REPORT UPDATE

Application No: M/91/13/

LOCATION: 33 Sea Way
Middleton-on-Sea
Bognor Regis

PROPOSAL: Enlargement of garage to north elevation

Site and Block Plan

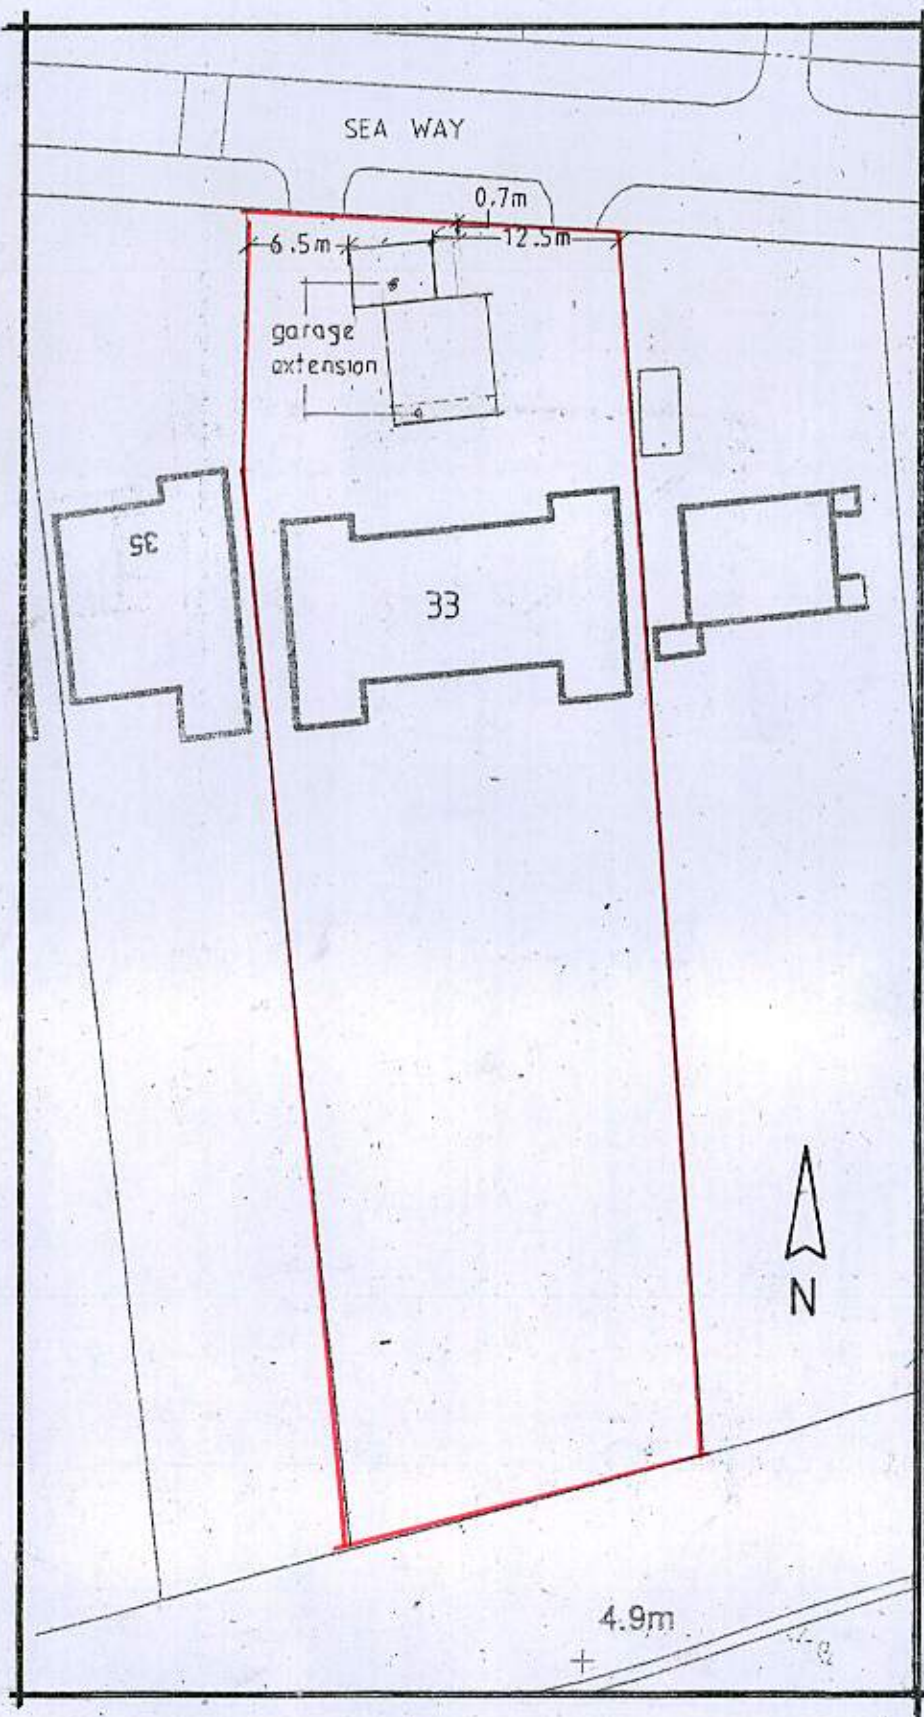
The applicant's initial proposal was proposed to be situated approximately 2.0 metres from the trunk of a Holm Oak Tree. The application form states that the tree will not need to be removed or pruned in order to carry out the proposal. During a site visit it was assessed that the proposed extension is likely to fall within the tree's root protection area. There is therefore a danger that the proposal would involve the excavation of tree roots that would make the tree unstable. The applicants have not submitted an arboricultural assessment or any other information on how the tree will be protected.

The Council's Parks and Greenspace officer considers that insufficient information has been submitted with the application to be able to assess whether the tree will be negatively affected, and if not what mitigation measures will be put in place to protect the tree during construction to ensure its continuing health.

As a result of the consultation response received from the Parks and Greenspace team the applicants have amended their proposal to move the extension away from the proposed tree. It is considered that the proposed development is now outside of the trees route protection area. Conditions have been included to ensure measures are taken to protect the tree during the construction phase.

- 4 No development including site access, demolition or associated construction activities, shall take place on the site unless and until the existing holm oak tree to be retained on the site has been protected by a fence in accordance with BS5837 (2012) and Section 9, to be approved by the Local Planning Authority for erection around the tree to a distance of 15m or to the Root Protection Area (RPA) as calculated in accordance with Table 2 of BS5837 (2012) to be agreed in writing by the Local Planning Authority. The fence shall be retained in place for the duration of the development.

Site and Block Plan

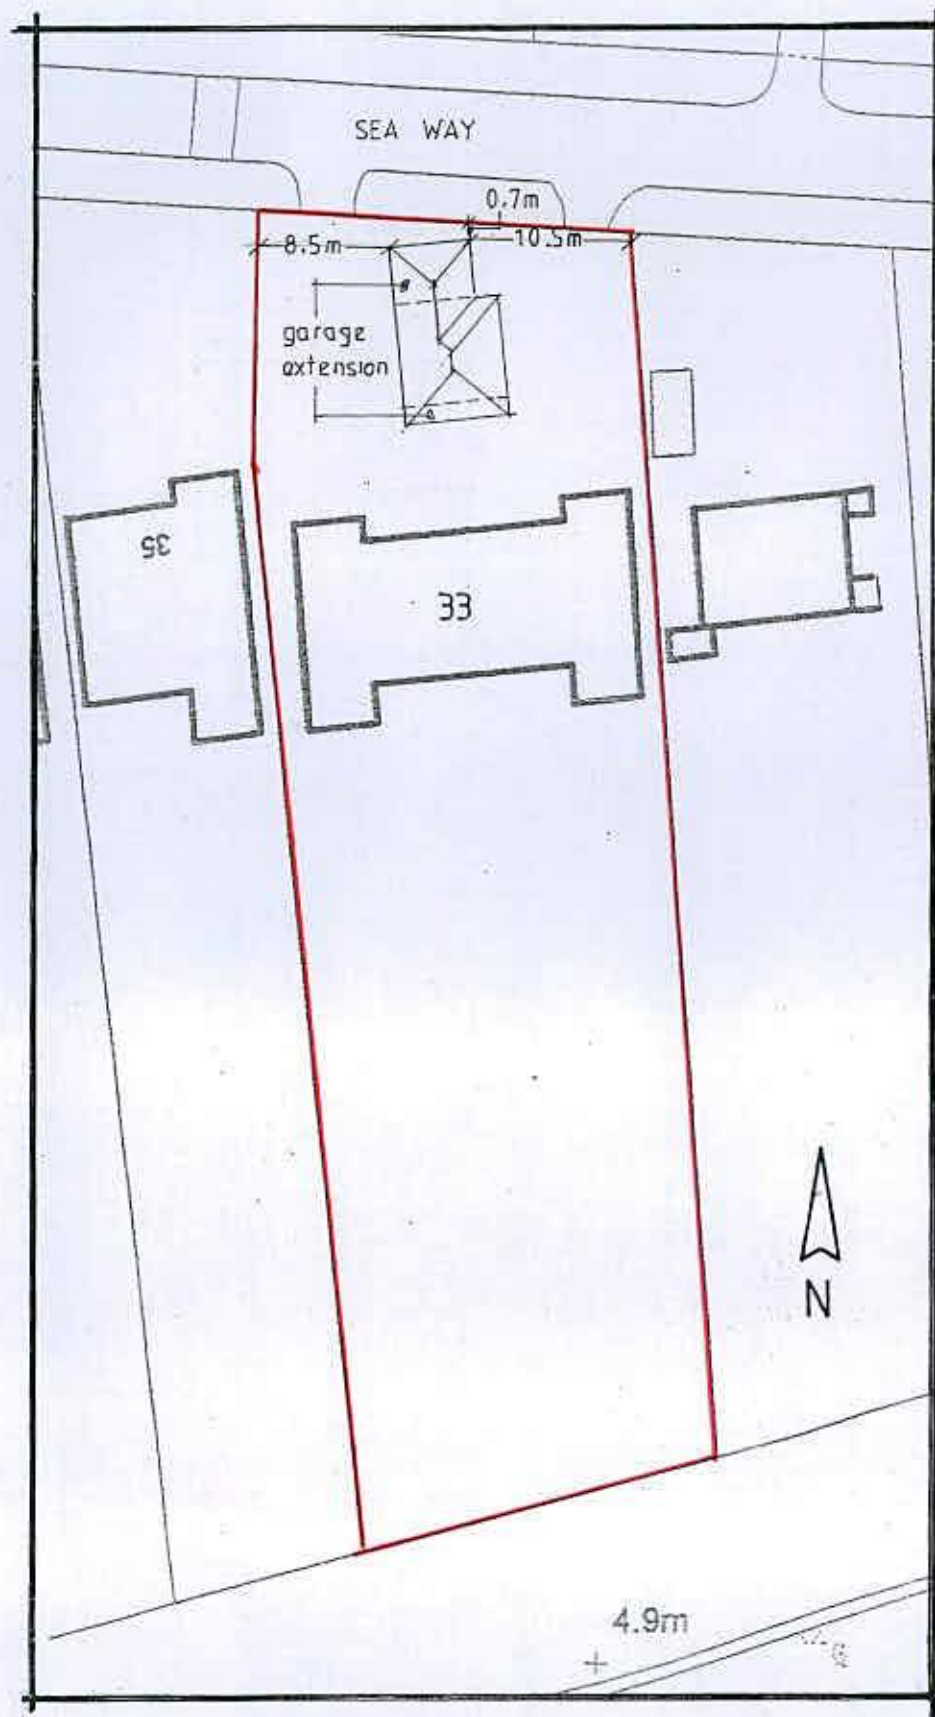
The proposal could mean the loss of a tree on the northern boundary, the tree has not been shown on the submitted plans, the tree adds to the visual character of Sea Way within this area of Special Character.

- significant tree to the front of the property Holm Oak, Quercus Ilex, which provides some screening and amenity value.
- Tree is not shown on the layout drawings.

- Application has stated that there are no trees or hedges that will need to be removed or pruned in order to carry out these works.
- The plan needs to be resubmitted correctly including and plotting of the existing Holm Oak, Quercus Ilex and the protection measures to be put in place for its retention. This should be in accordance with BS 5837:2012 'Trees in relation to construction' and the protection methods that this sets out.

The applicants have amended the scheme to move part of the development further from the Holm Oak tree to ensure its long term vitality.

Proposed Plan

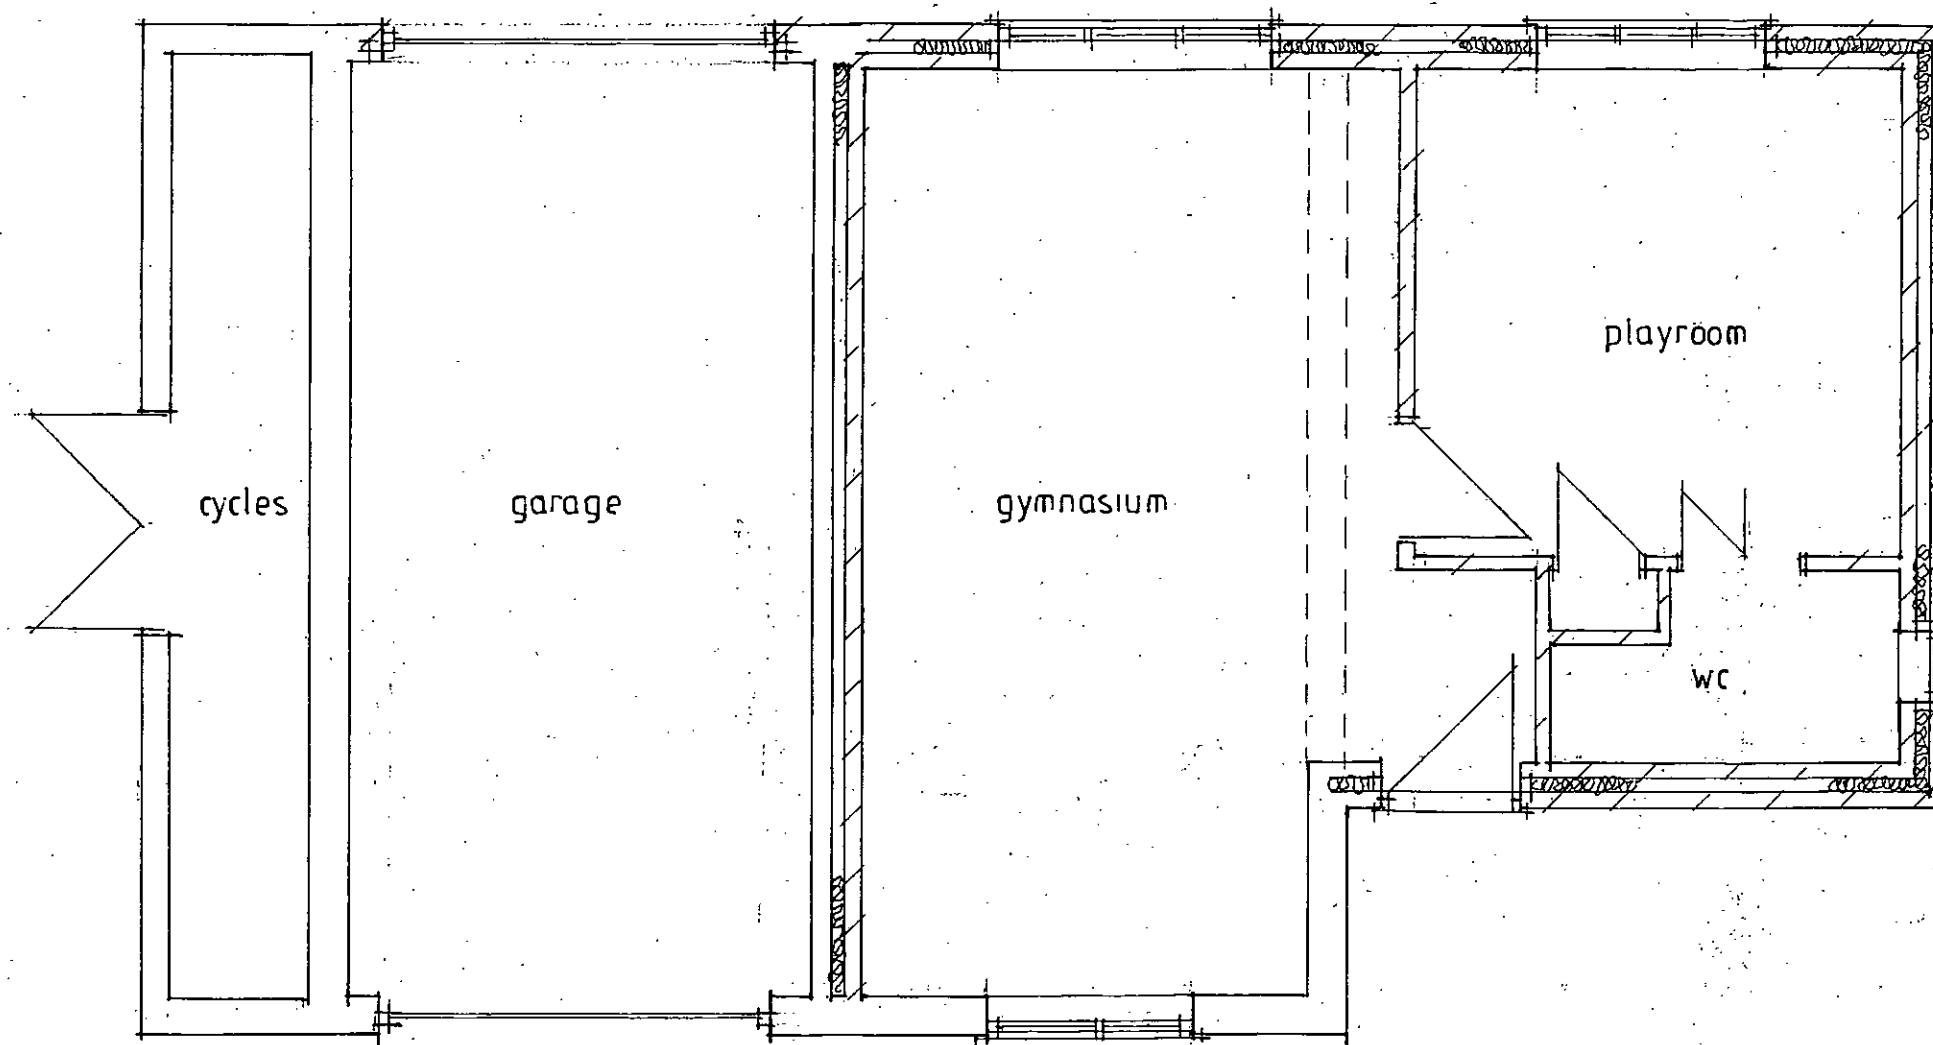
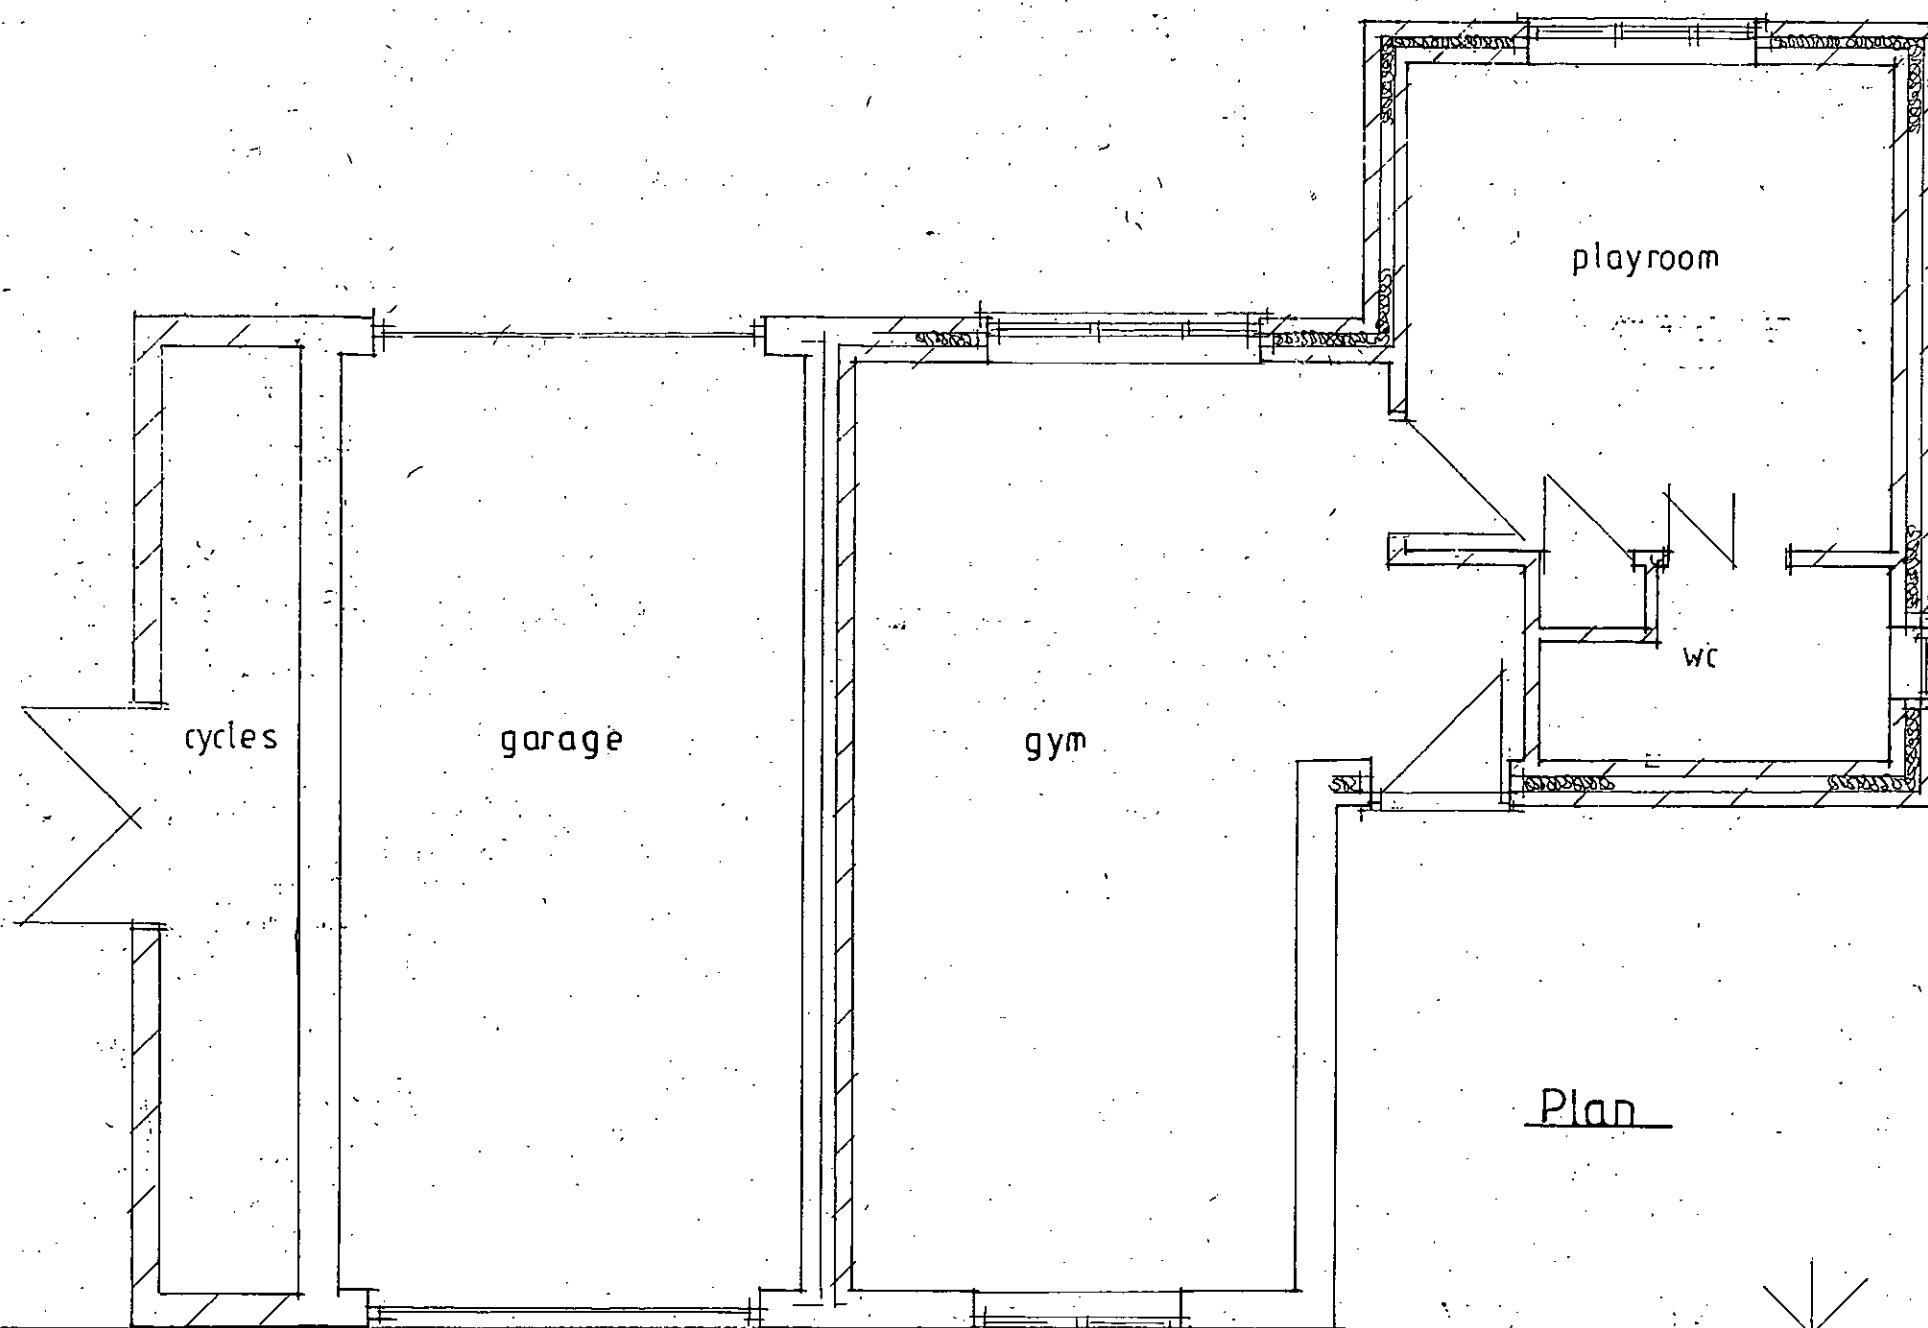
The proposed development is to extend an existing detached garage and make a number of amendments to the proposed elevations including new windows, doors and internal amendments to provide a cycle store, gymnasium, playroom and toilet. The proposed development would extend the garage northwards towards Sea Way by approximately 5 metres.

The proposed extension is to the north of the existing garage and will be situated between the garage and the front wall. The proposed extension's roof ridge is stepped down from the height of the existing and the eaves levels are proposed to match the existing. The extension will have a pitched roof at an angle to complement the pitch of the existing roof. The materials are proposed to match the existing garage.

It is not considered that the extension which measures 4 metres deep and 5 metres wide is of a mass and scale that is out of keeping with the host building. Though sited between the existing garage and the highway, the impact on the street scene will be minimised by the existing front boundary wall and mature foliage.
